DRAINAGE AND GRADING REQUIREMENT FOR LOTS A-1, A-2 AND A-3, BLOCK D, GLENRIO
HEIGHTS ADDITION

September 21, 1982

RE: CONCEPTUAL GRADING & DRAINAGE PLAN FOR GLENRIO HEIGHTS LOTS 4-16 &
25-28, BLOCK D

CONCEPTUAL GRADING & DRAINAGE PLAN

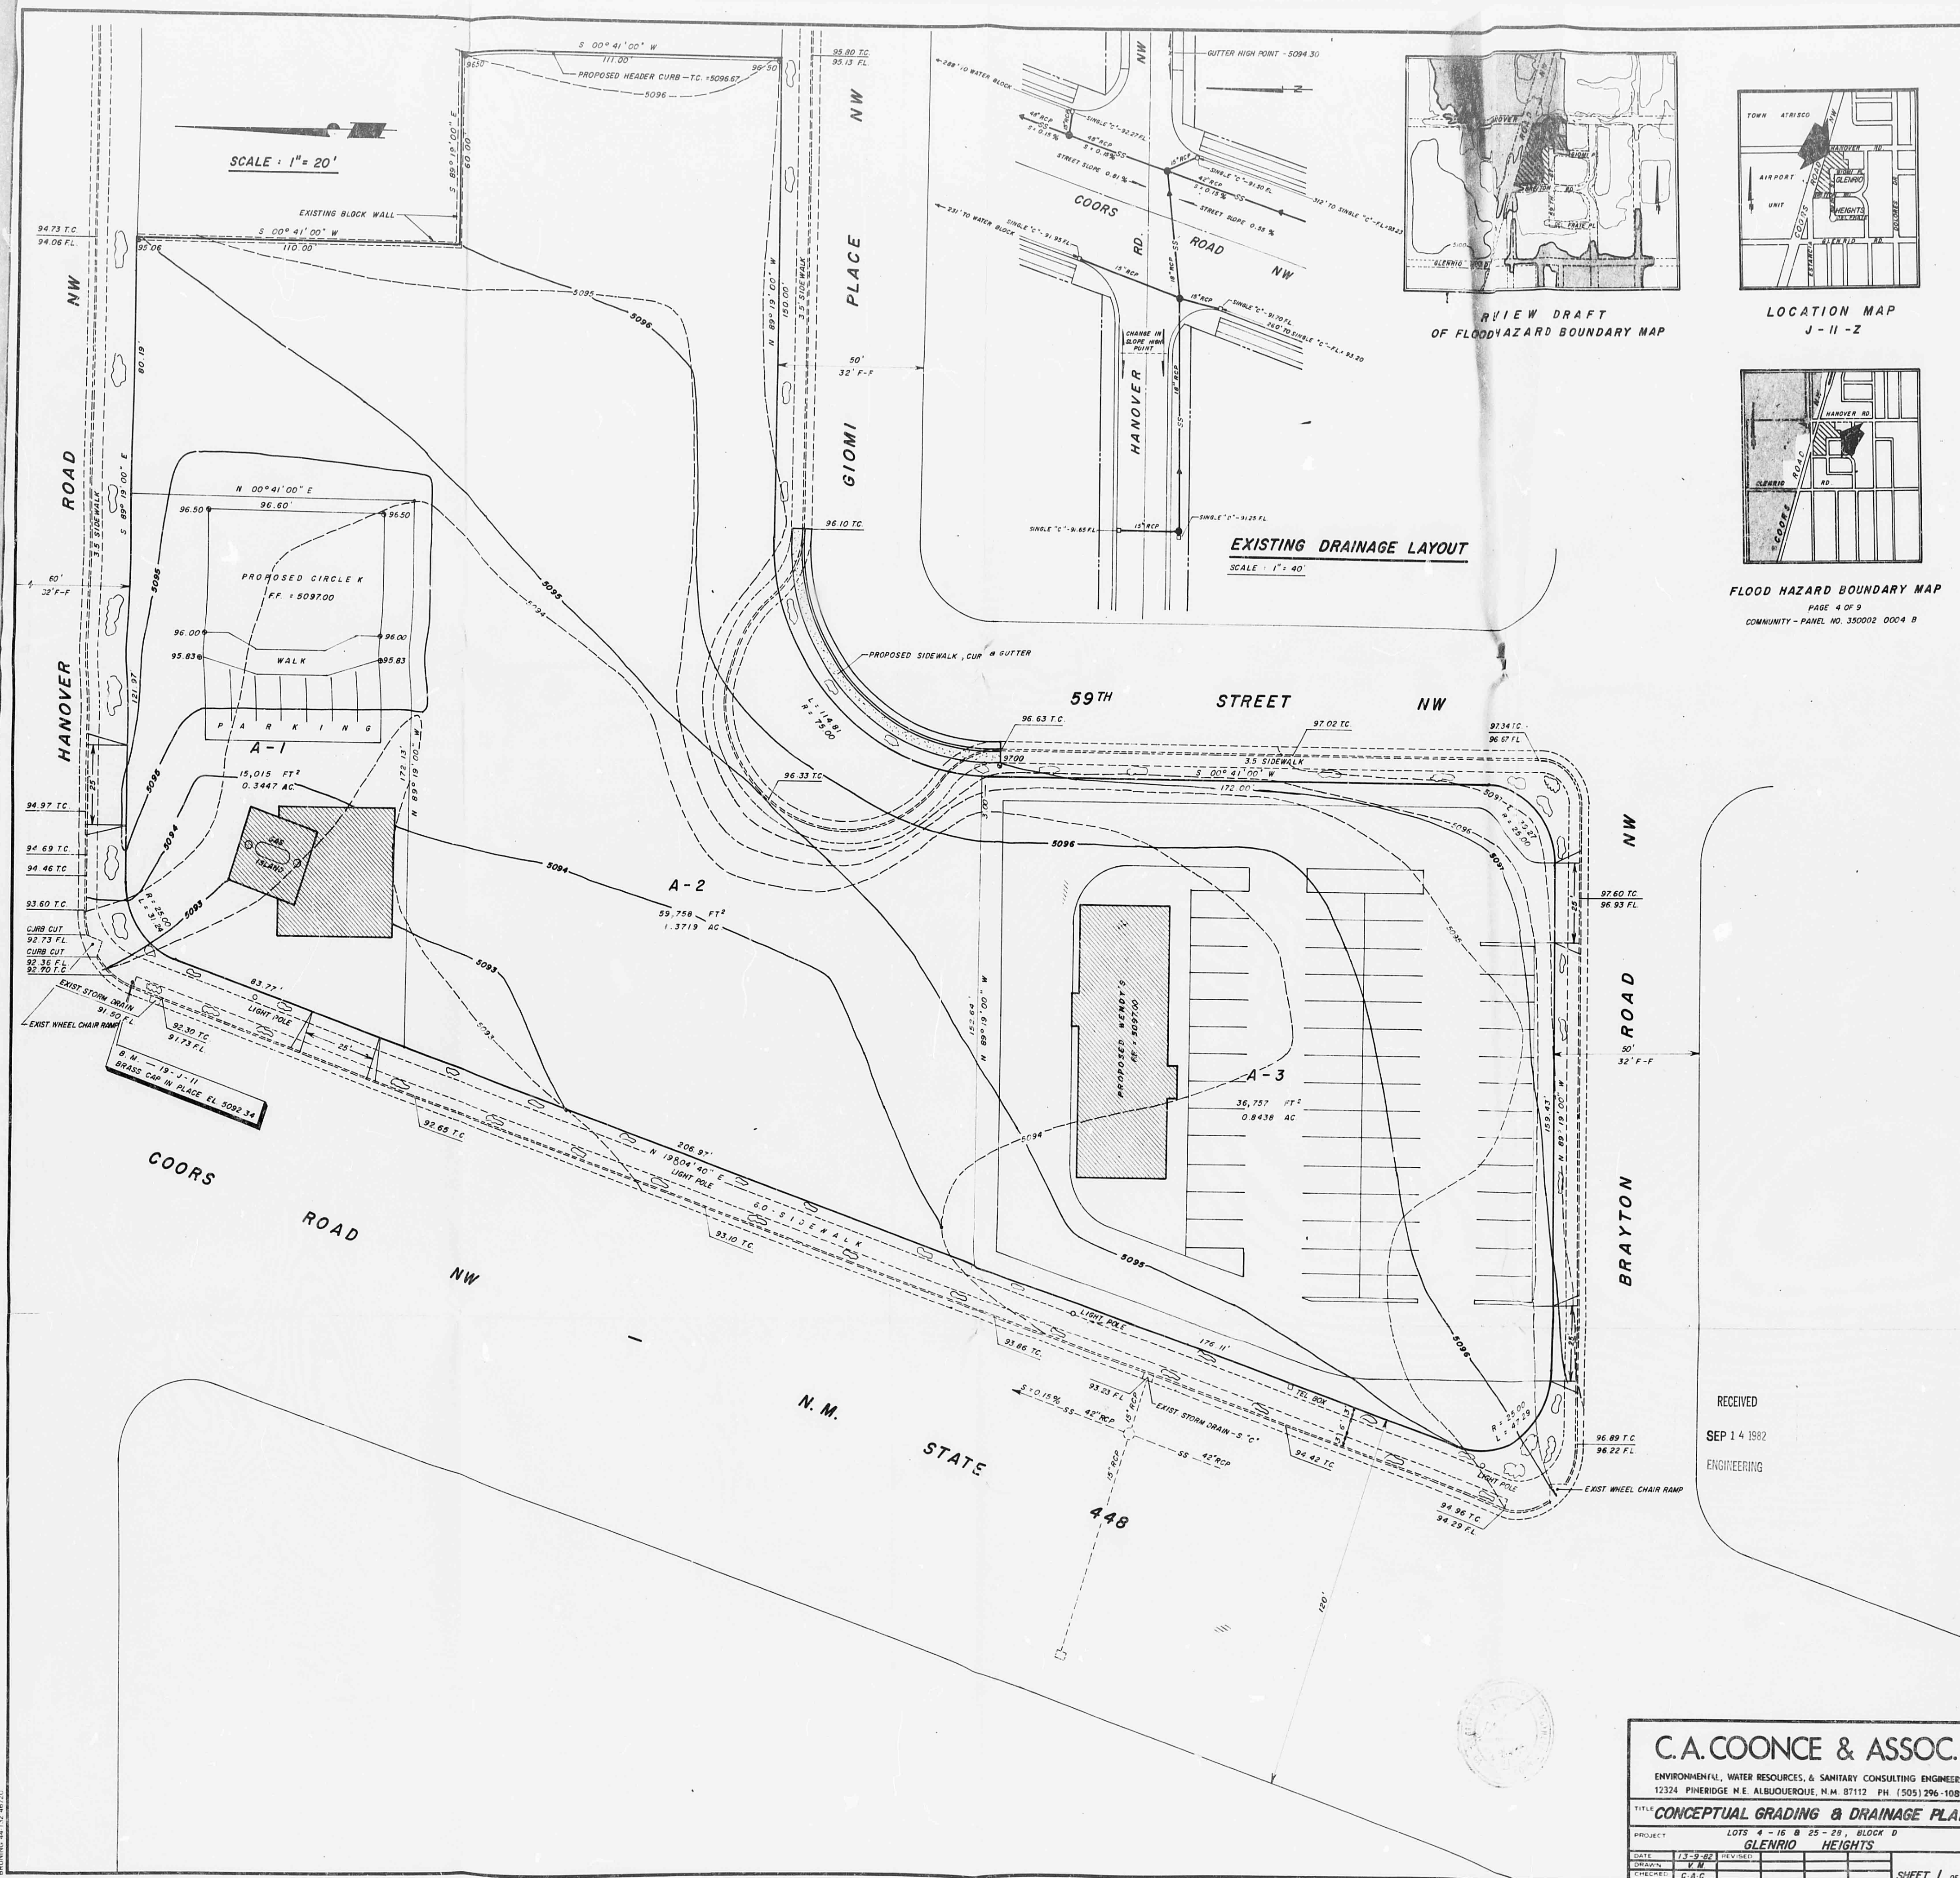
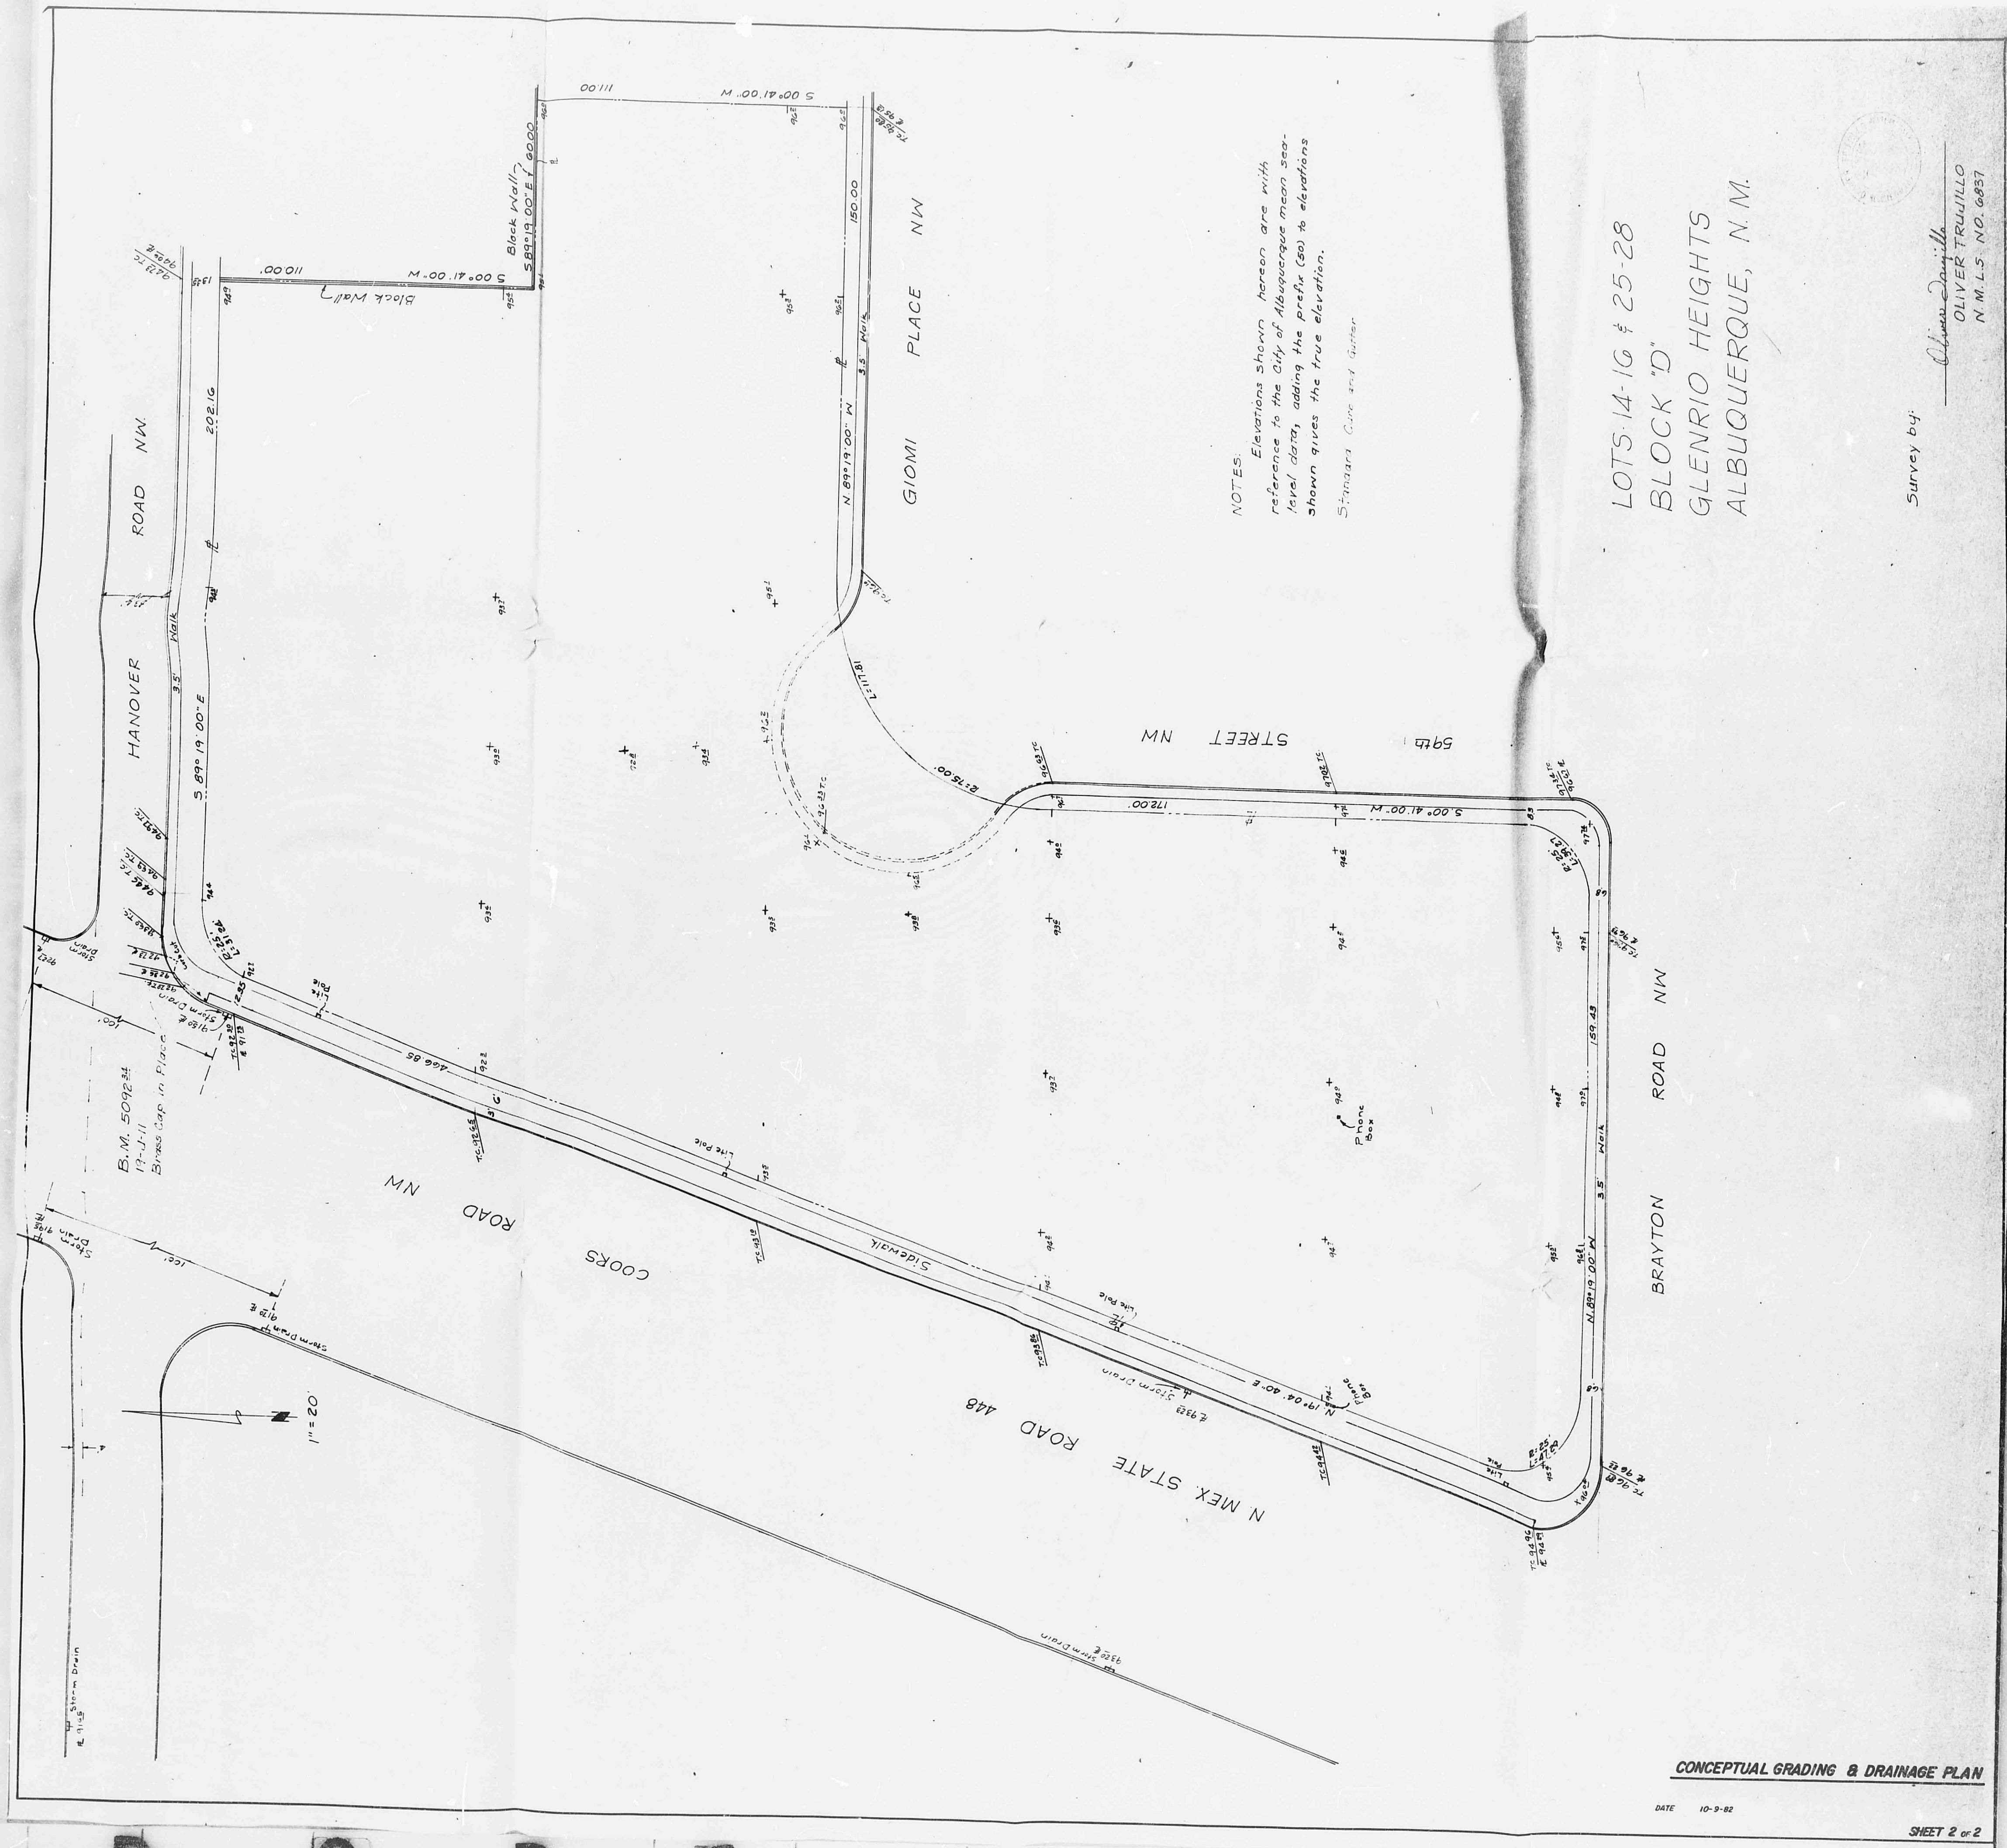
Comment: What watershed was used in the analysis? Did the analysis just investigate flows generated in Coors Blvd. or did it incorporate runoff generated by contributing streets and developments?

Comment: What is the capacity of the storm sewer? How does this capacity compare to the total runoff generated in the watershed?

Comment: The Dec. 1979 maps are no longer the current document for obtaining flood hazard information. This office is permitted to use the maps prepared by Bohannon-Huston for studies of this type. How was it confirmed that the former maps incorporated the storm sewer into the analysis?

Comment: Where was this value obtained? What is the definition of a "unit area of watershed"?

Comment: This statement must be verified quantitatively. Assumptions should also be included.

Comment: How was this conclusion reached? The rate at which runoff leaves a site is determined by the capacity of the downstream drainage system. Also, the 100-year storm event is used to analyze the system.
